About the application

Application number: 2026/92450	
What is the application for?:	Demolition of existing workshop and erection of detached dwelling
Address of the site or building:	Workshop between, 12 & 14/16, Temple Street, Lindley, Huddersfield, HD3 3JG
Postcode:	HD4 6HF

Type of comment: An objection	
Do you wish your comments to be published on the website anonymously?	Yes

Revision	Description	Issued	Checked	Date
Client: Mr & Mrs McGowan				
Project: The Workshop, Temple Street, Lindley.				
Drawing: Scheme As Proposed				
Drawing Status: PLANNING				
Date: FEB 26	Scale @ A1: 1:100	Drawn by: AB		
Project No: 298	Drawing No: (0-) 02	Revision:

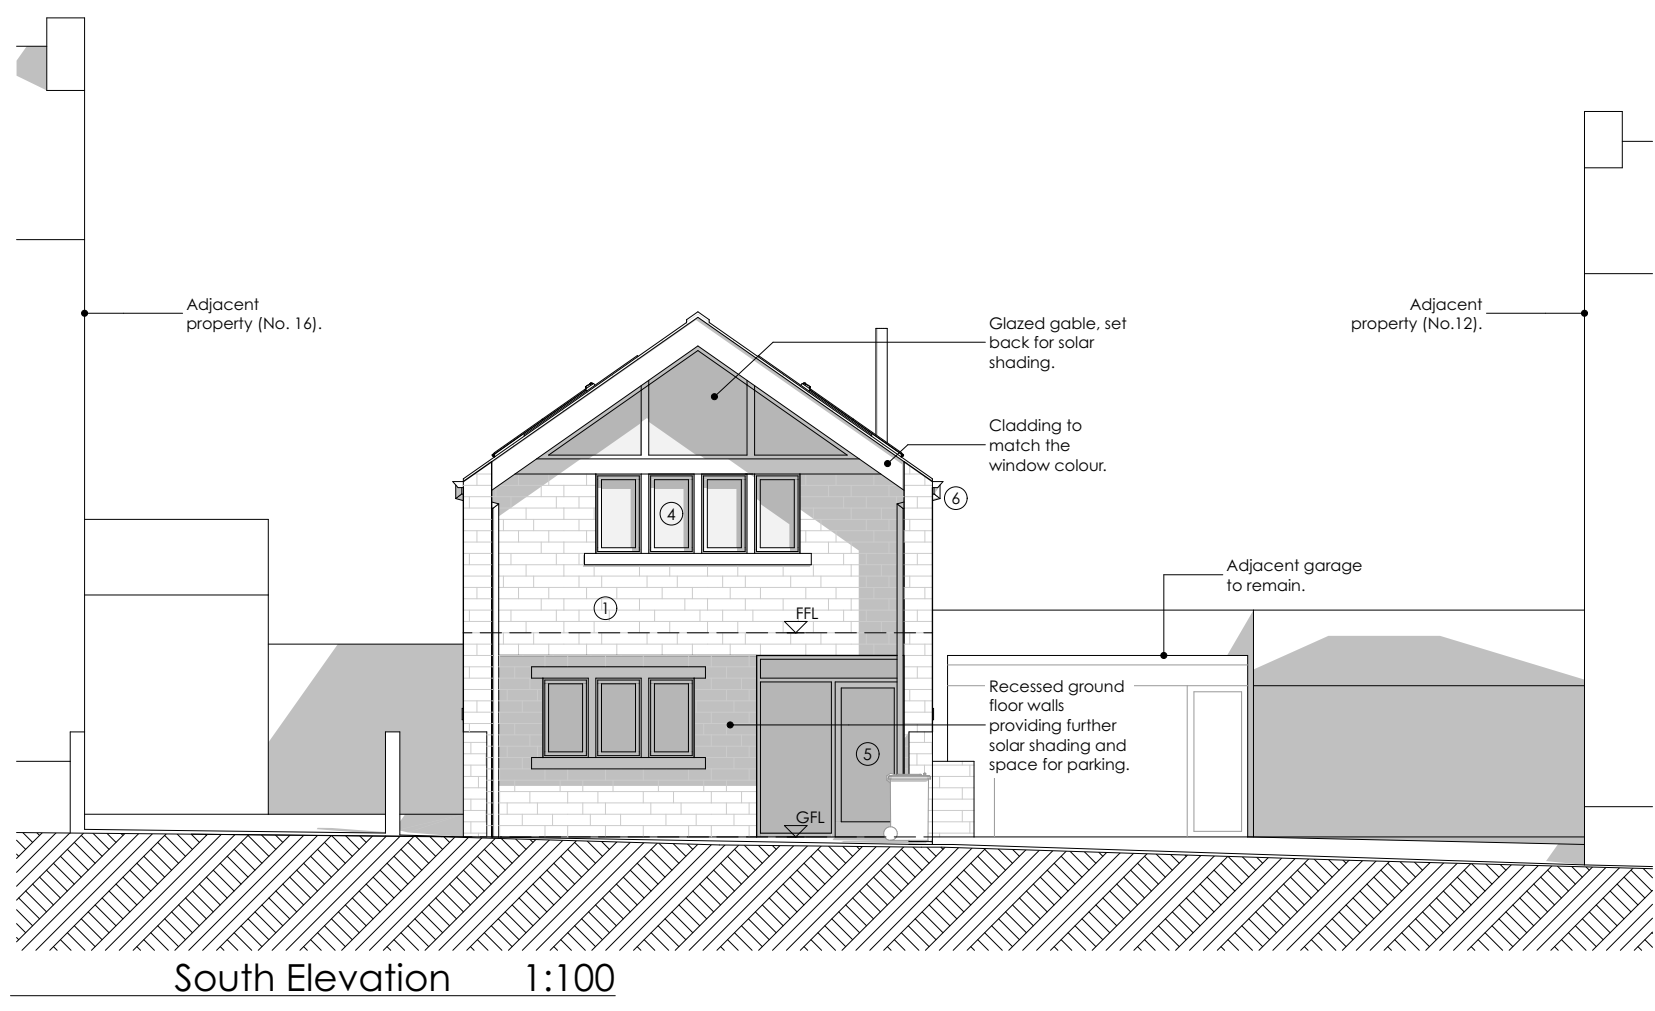
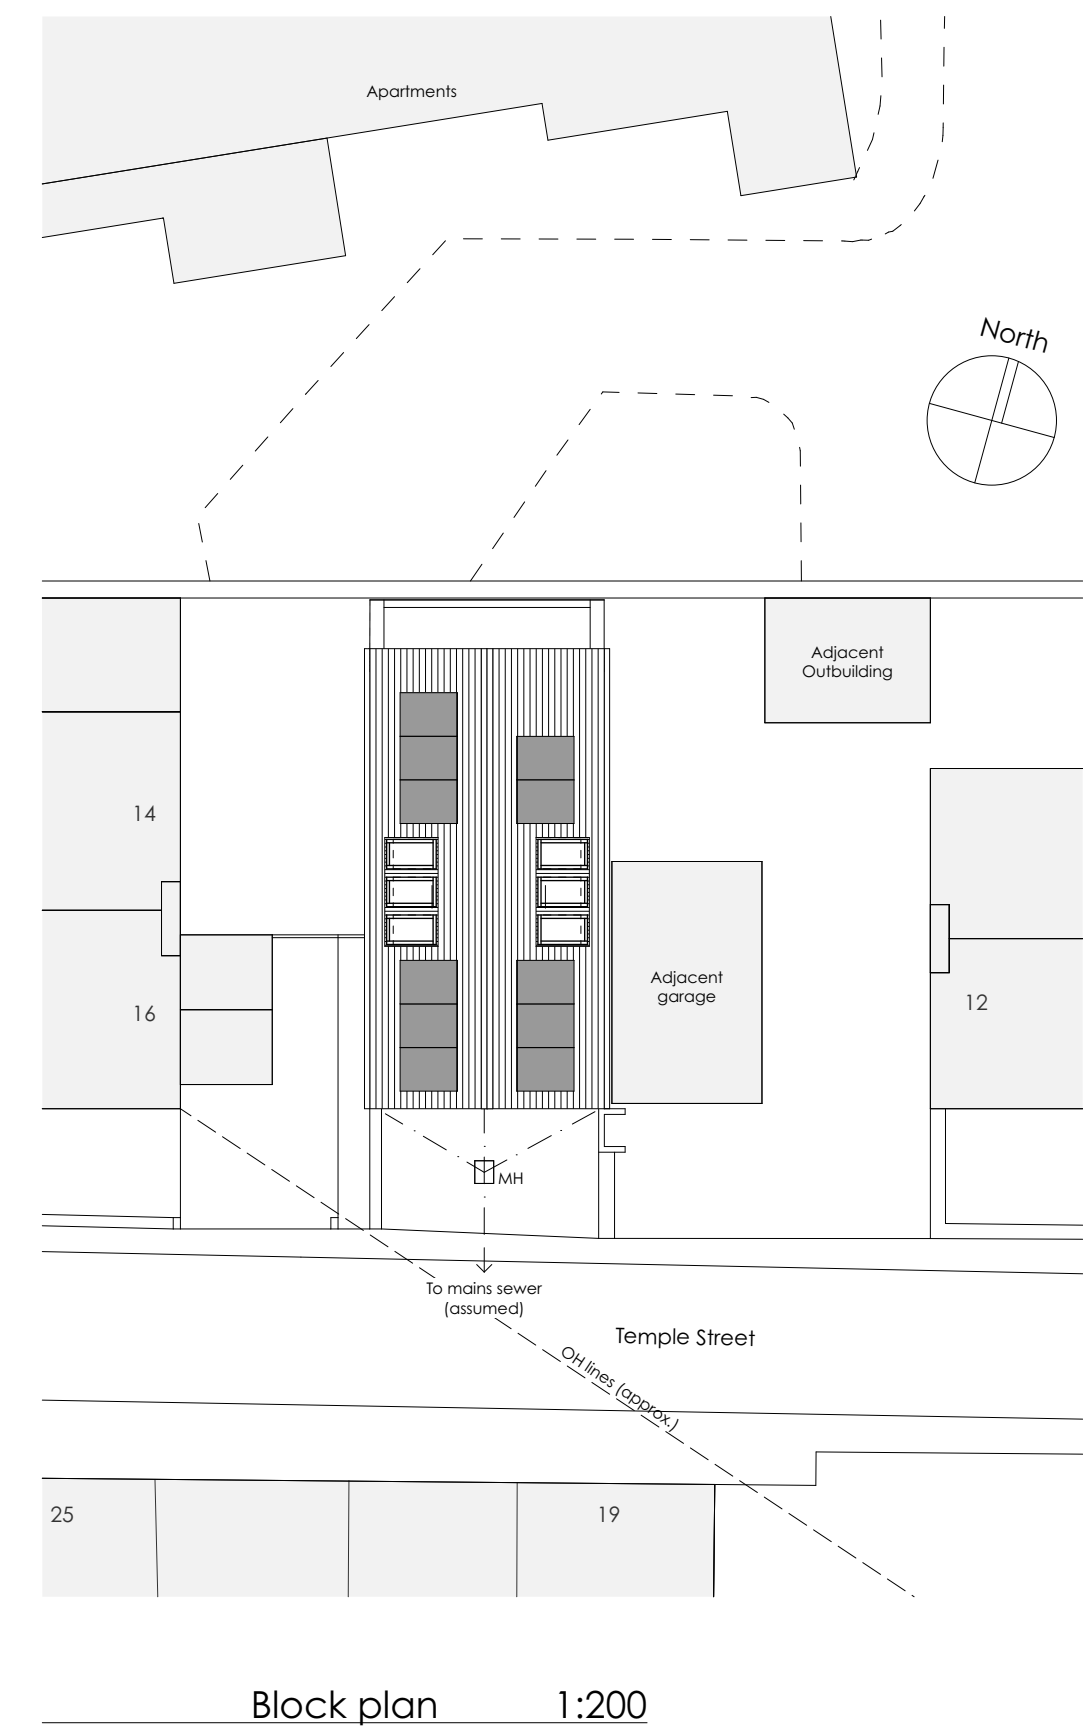
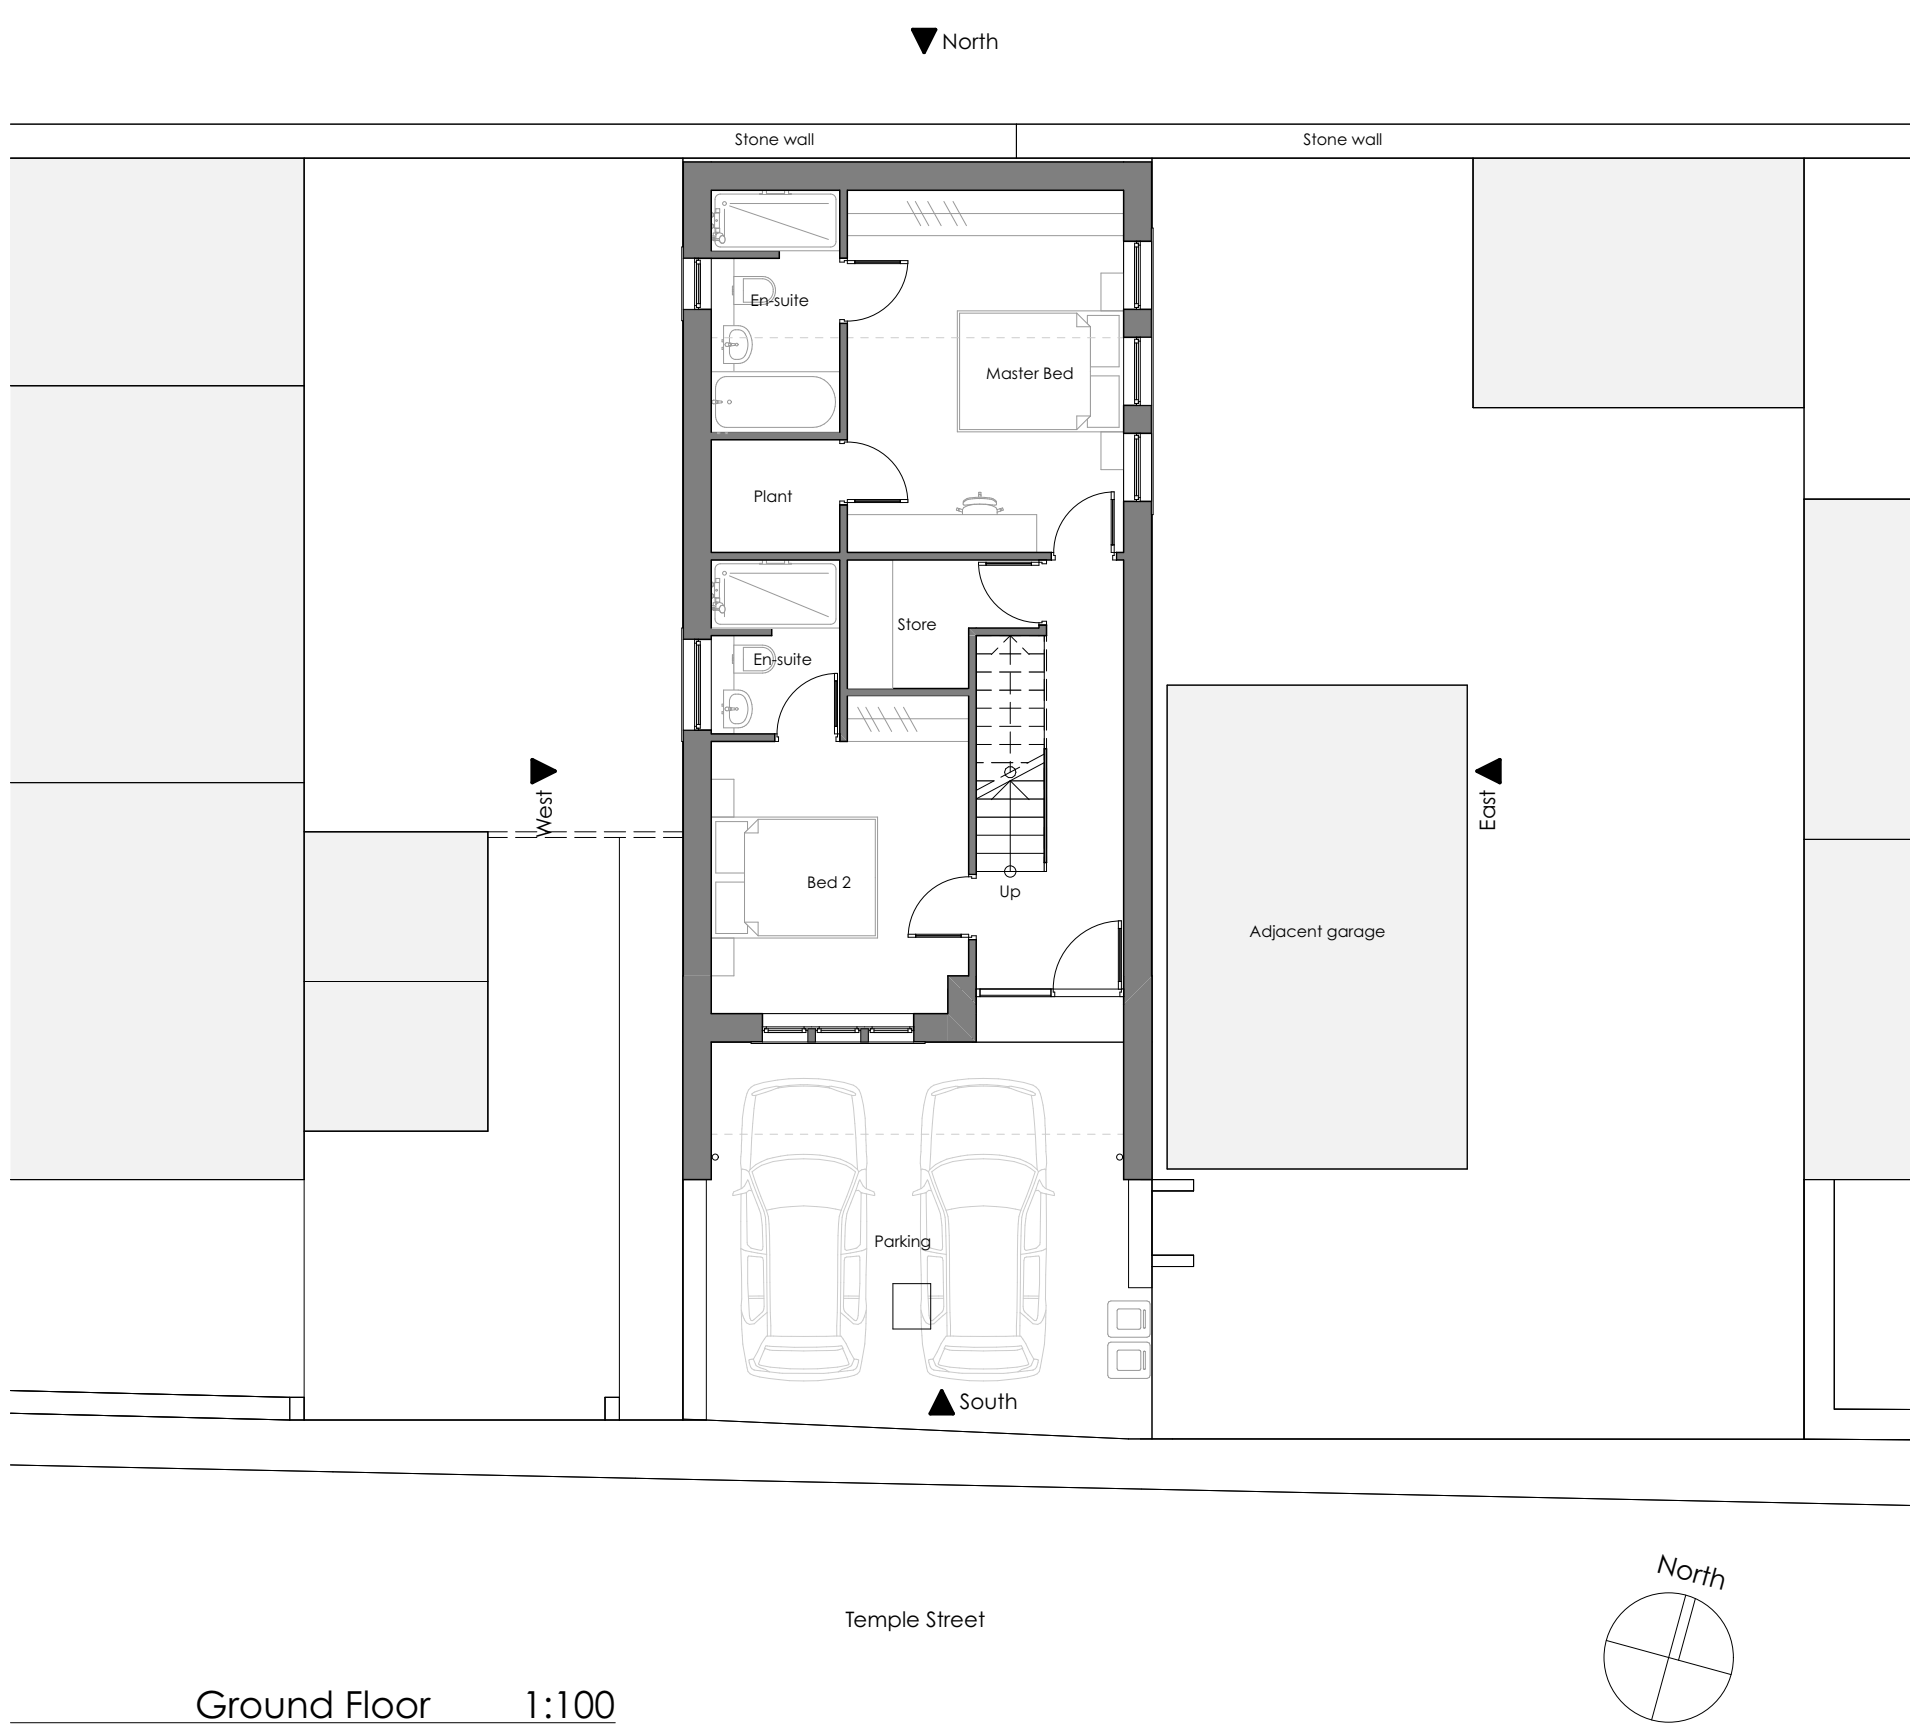
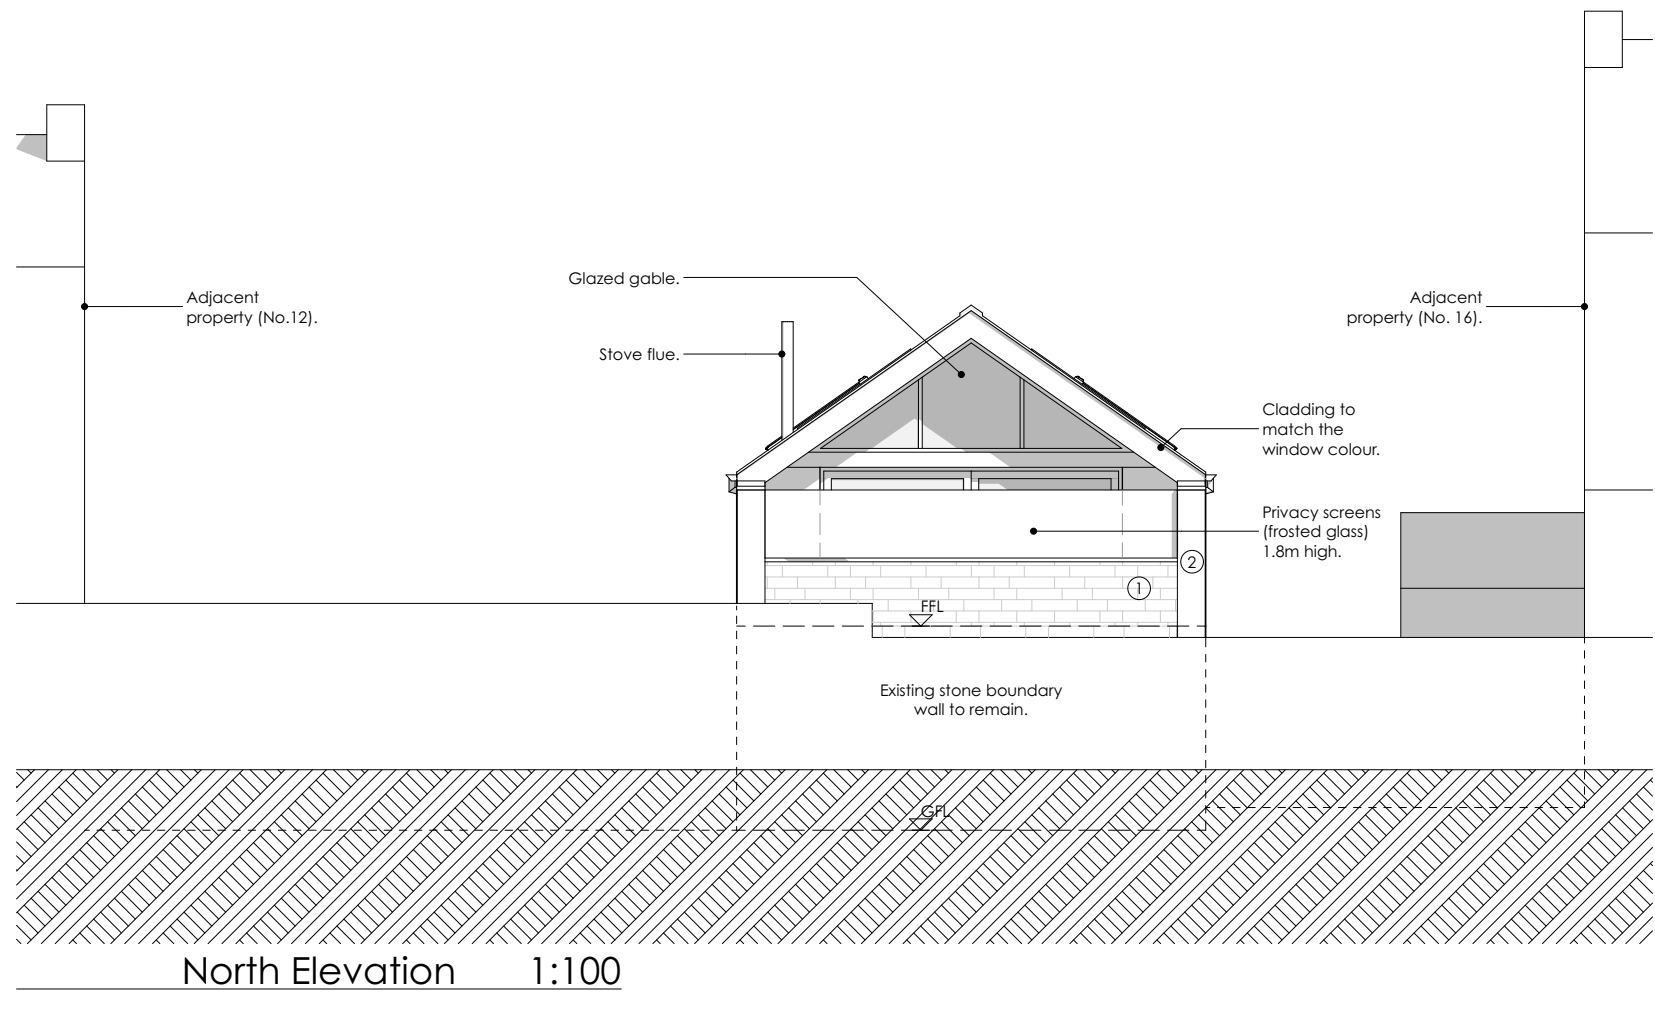
I am writing to formally object to the planning application referenced above. My property and private patio directly adjoin the boundary of the proposed development. While I note the applicant has attempted to satisfy privacy guidelines regarding overlooking by specifying obscured glass and a 1.7m finished floor level (FFL) restriction for the proposed side window, the current architectural design is unworkable and fundamentally flawed under property law for the following reasons:

Encroachment and Civil Trespass of Airspace: The proposed layout positions the new dwelling directly against my property boundary. Any outward-opening mechanism or top-hung hatch on this window will inevitably swing across the legal boundary line, causing a continuous and actionable civil trespass into my private airspace. A developer cannot rely on planning permission to overwrite established property boundaries.

Impact on Amenity and Safety: The airspace into which this window will open sits directly above my private outdoor patio. An outward-opening window creates an unreasonable safety hazard to anyone utilising my patio and restricts the full, unhindered enjoyment of my own land.

Lack of Maintenance Feasibility: Because the window opens directly over my boundary line, it cannot be cleaned, repaired, or maintained by the future occupiers without physically entering my private property. I do not grant permission for access to my land for routine window maintenance, rendering this element of the building design unsustainable.

Requested Action / Condition: I strongly urge the Planning Committee or Case Officer to refuse this layout in its current form. Should the council be minded to approve this application despite this flaw, I request that a strict, legally binding planning condition be attached to the decision notice. This condition must mandate that this specific window be entirely fixed-shut (100% non-opening) or designed as an inward-opening (tilt-and-turn) window only, ensuring that no part of the frame, glass, or mechanism can ever breach the boundary line into my property.

The current architectural drawings indicate that the proposed building's east wall is positioned directly on the boundary line. Consequently, any standard roof eaves, fascia boards, or guttering systems attached to this roofline will inevitably project outwards and overhang directly into my private property and over my patio.

This constitutes a permanent civil trespass of my airspace and poses a significant risk of water runoff discharging onto my land. I request that the developer be required to amend their plans to set the entire building footprint back from the boundary line, ensuring that all guttering, eaves, and subterranean foundations remain 100% within the applicant's own legal land boundaries.
